RE: INTERIM AUDIT ADVICE LETTER NO. 4 - SSD 8925 MOD 7, THE NEW SYDNEY FISH MARKET

Ramboll Australia Pty Ltd
Level 3, 100 Pacific Highway
PO Box 560
North Sydney NSW 2060

This fourth Interim Audit Advice Letter (**IAA #4**) has been prepared to address new requirements for Condition B93 which requires audit review of the letter 'Re: *Sediment Capping – Environmental Assessment, New Sydney Fish Market*', 15 February 2022, Senversa Pty Ltd (Senvessa) (**the Capping Methodology Letter**).

COFFERDAM PROTEINING PLAN

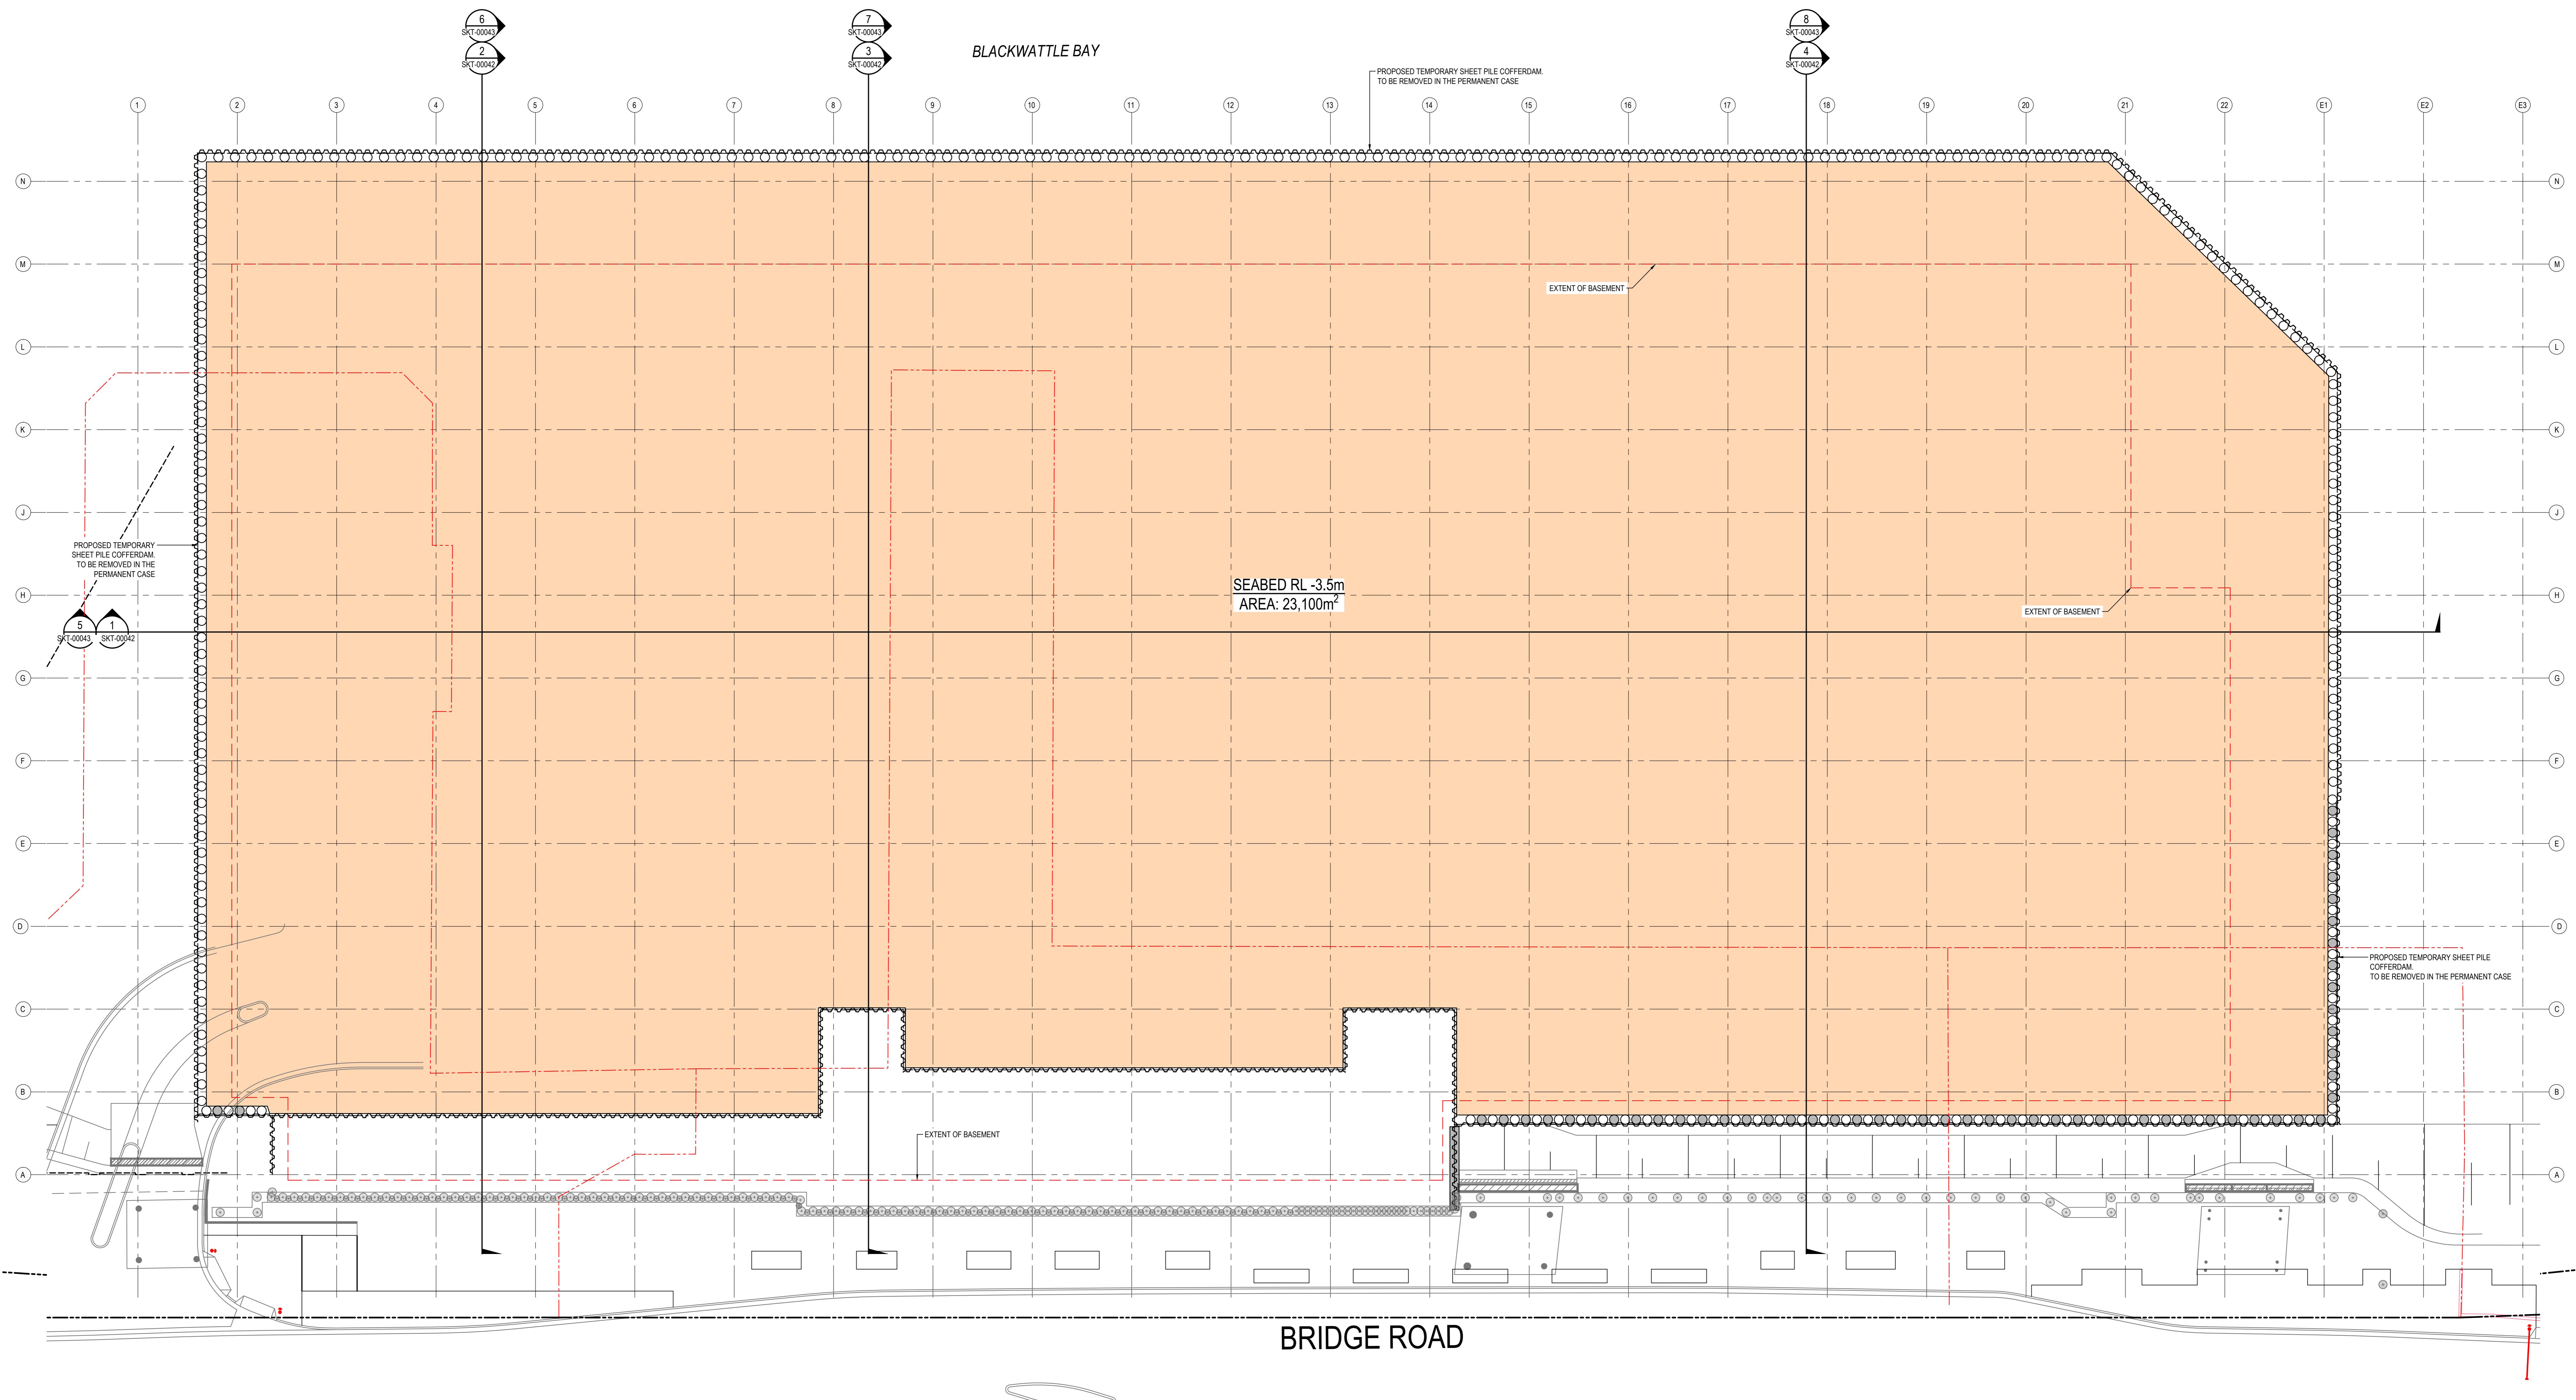
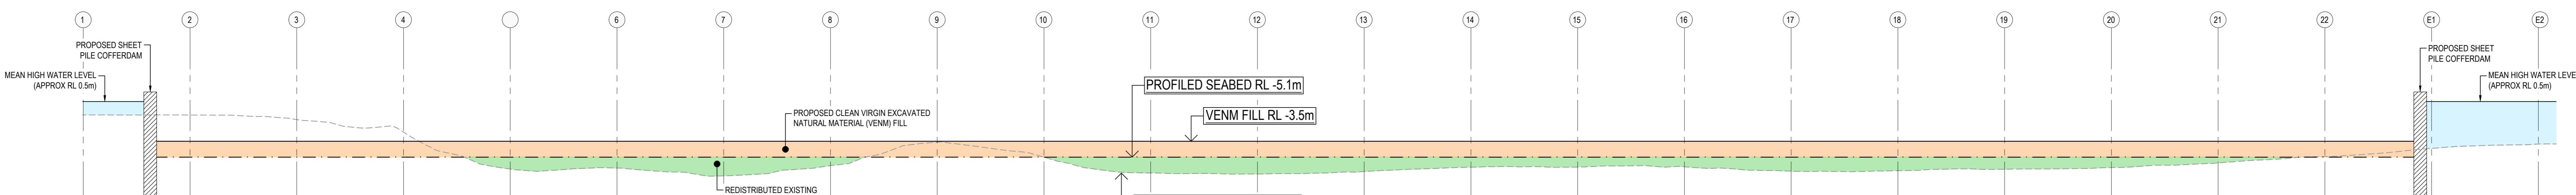
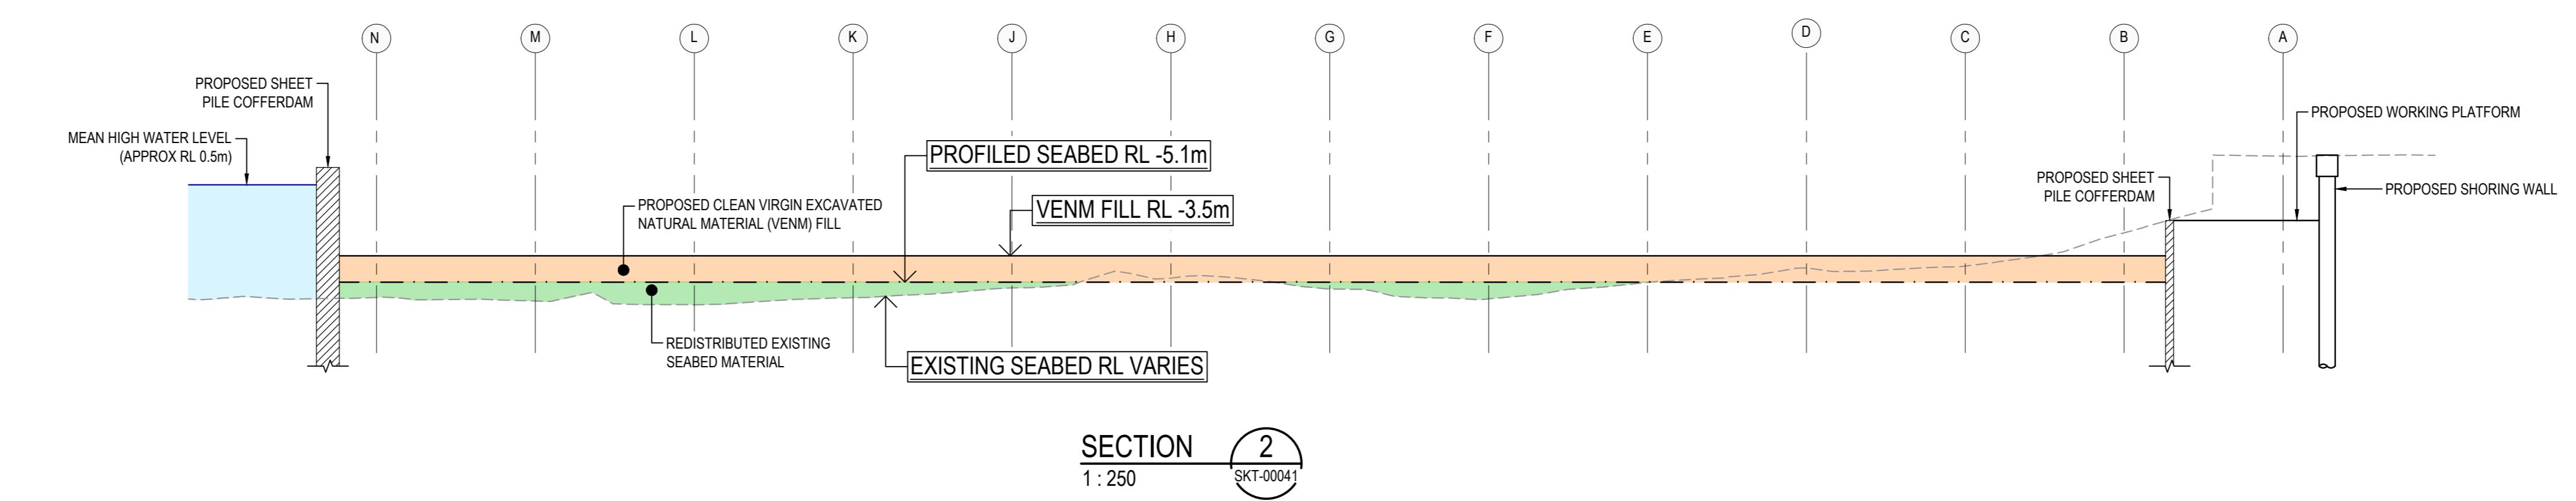
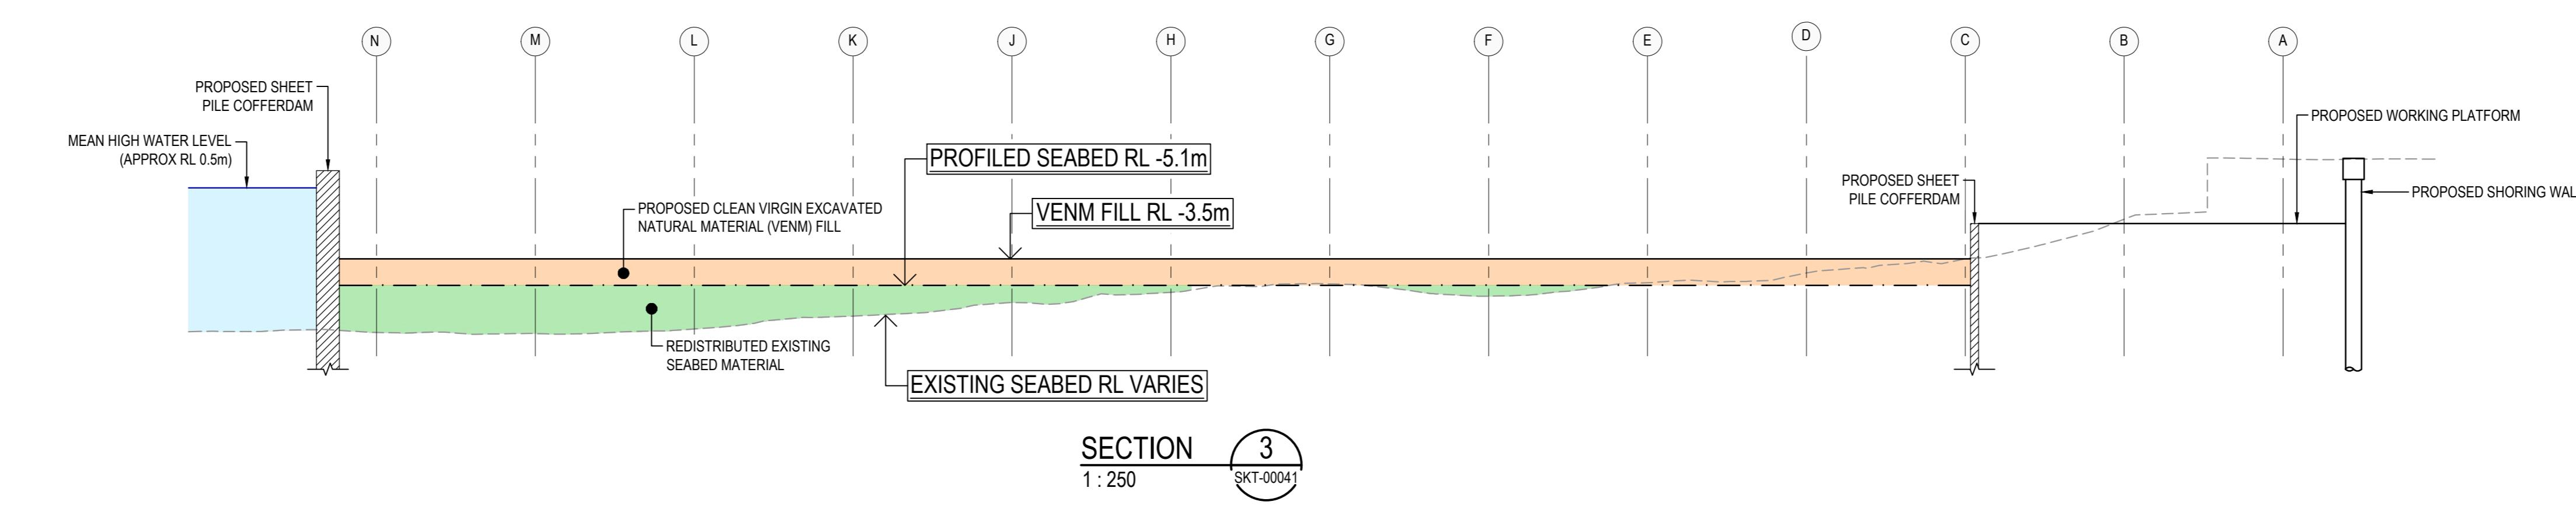
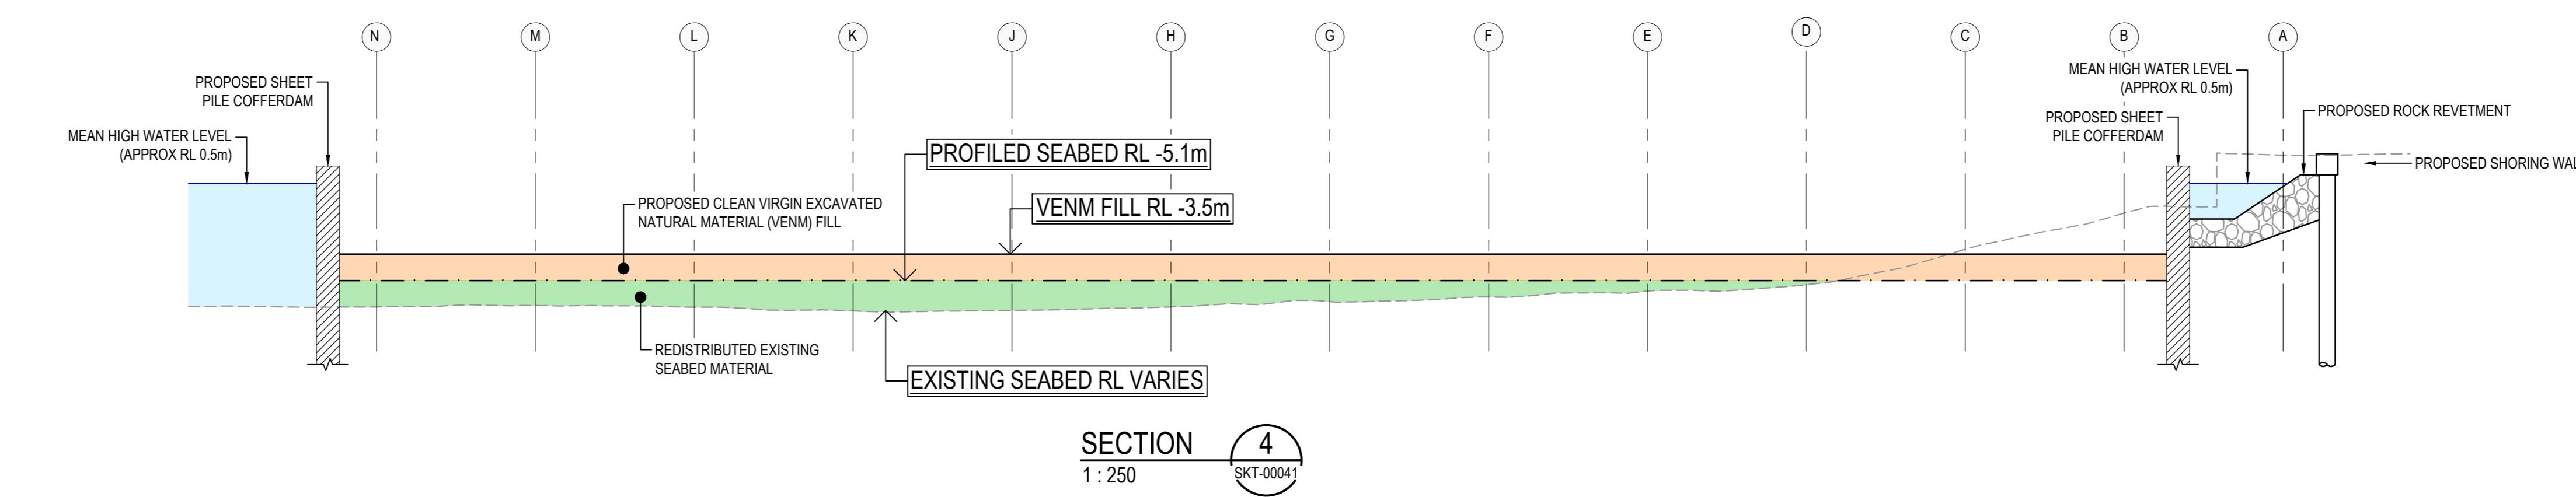
MOD 7 proposes capping of the sediments prior to dewatering to create a dry working platform within the cofferdam. The cap will be placed over approximately 23,100 m² of sediments (i.e., the area within the coffer dam) as shown on **Attachment 2**.

Given that the sediments are to remain water-logged, the proposed works are not expected to result in significant oxidation. Therefore, subject to appropriate validation of the imported VENM in accordance with the Revised RAP, I am of the opinion that the proposed capping is acceptable.
